From: Zac Denton
Sent: 25 July 2019 09:34
To: Planning Scanning
Subject: FW: Mistletoe Farm, Horsemere Green Lane. CM/13/19/RES; Revised Drainage Proposals
Attachments: ES1820-602-04 B Drainage Strategy with Ditch.pdf; cm1319res tree retention and protection plan.pdf

Subject: Mistletoe Farm, Horsemere Green Lane. CM/13/19/RES; Revised Drainage Proposals

Tree Retention & Protection Plan

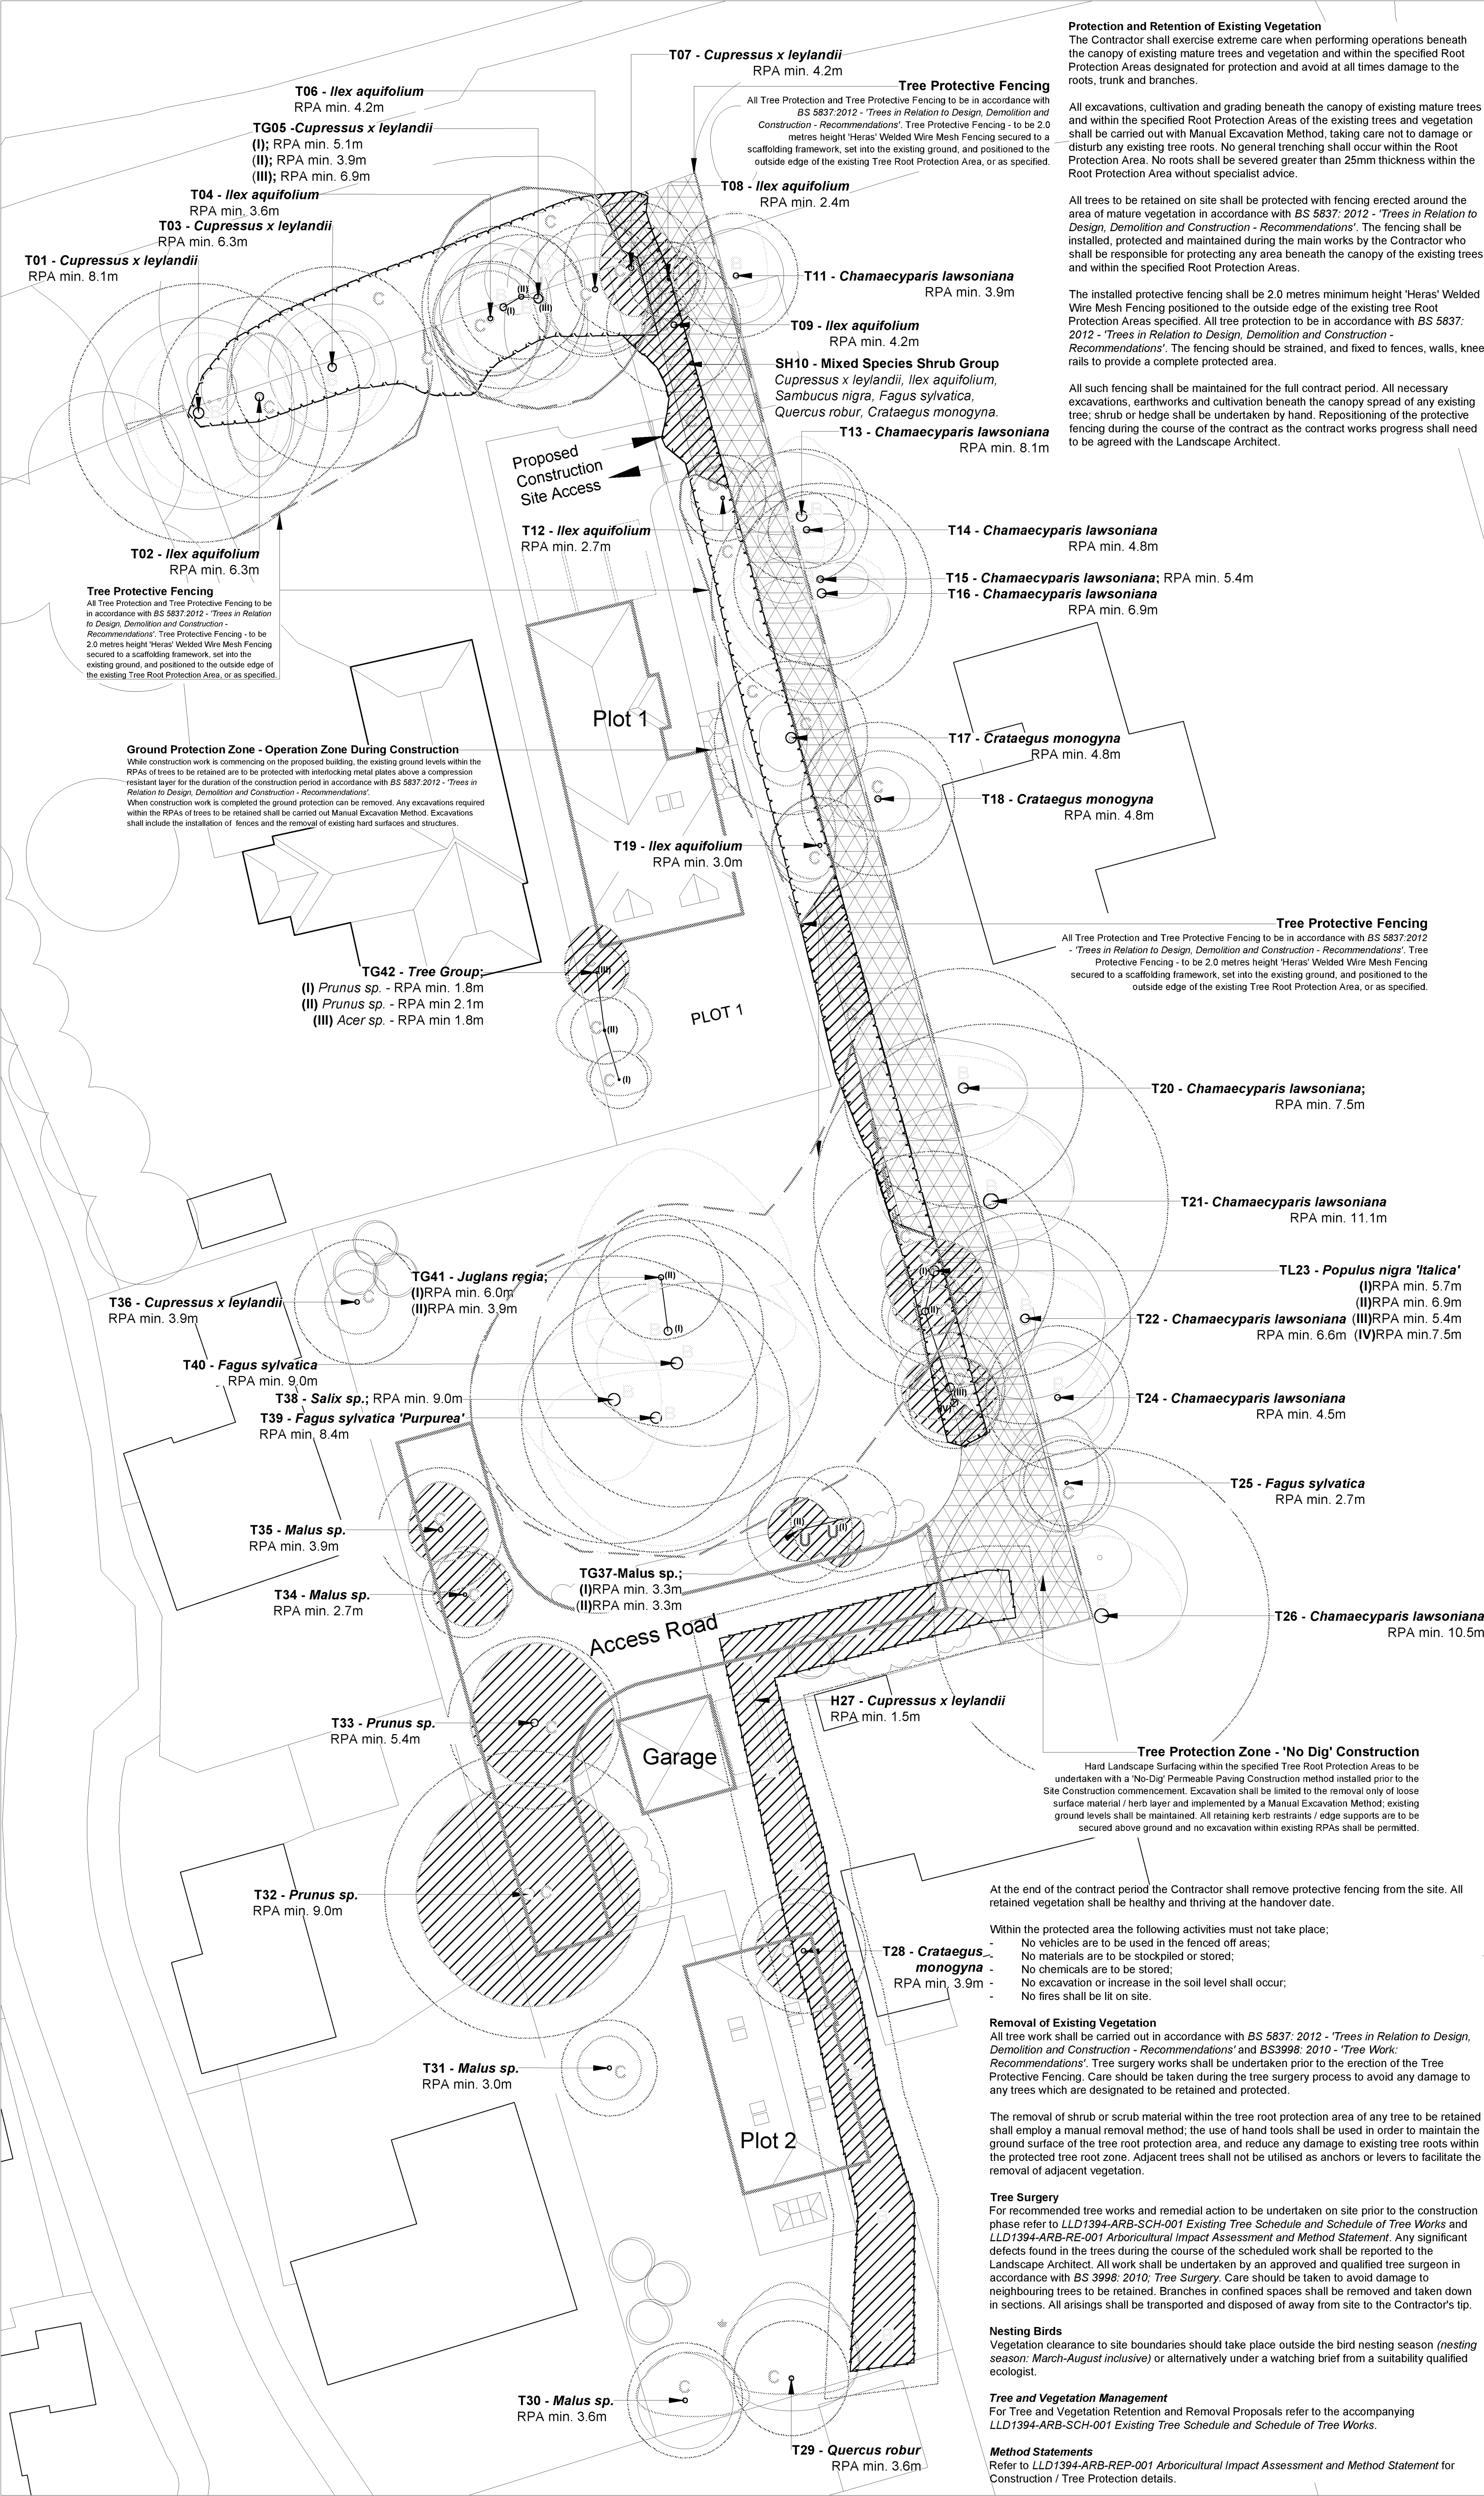
Thank you for sending over the revised plan. I believe there is some conflict between what you are proposing and the tree protection plan (attached).

The permeable paving for plot 2 looks like it could only be located in the T furthest round on the road rather than at the junction of roads 1 and 2. The swale also appears to be within a no dig area.

Thank you for your comments. I was under a misapprehension regarding the RPZ so having cleared that I have put together a revised proposal which addresses your comments on the RPZ. Hopefully you find this revised proposal accords with your thoughts and you are able to advise your planning colleague that we have reached a drainage solution. As always, if you have any further concerns please contact me. Many thanks.
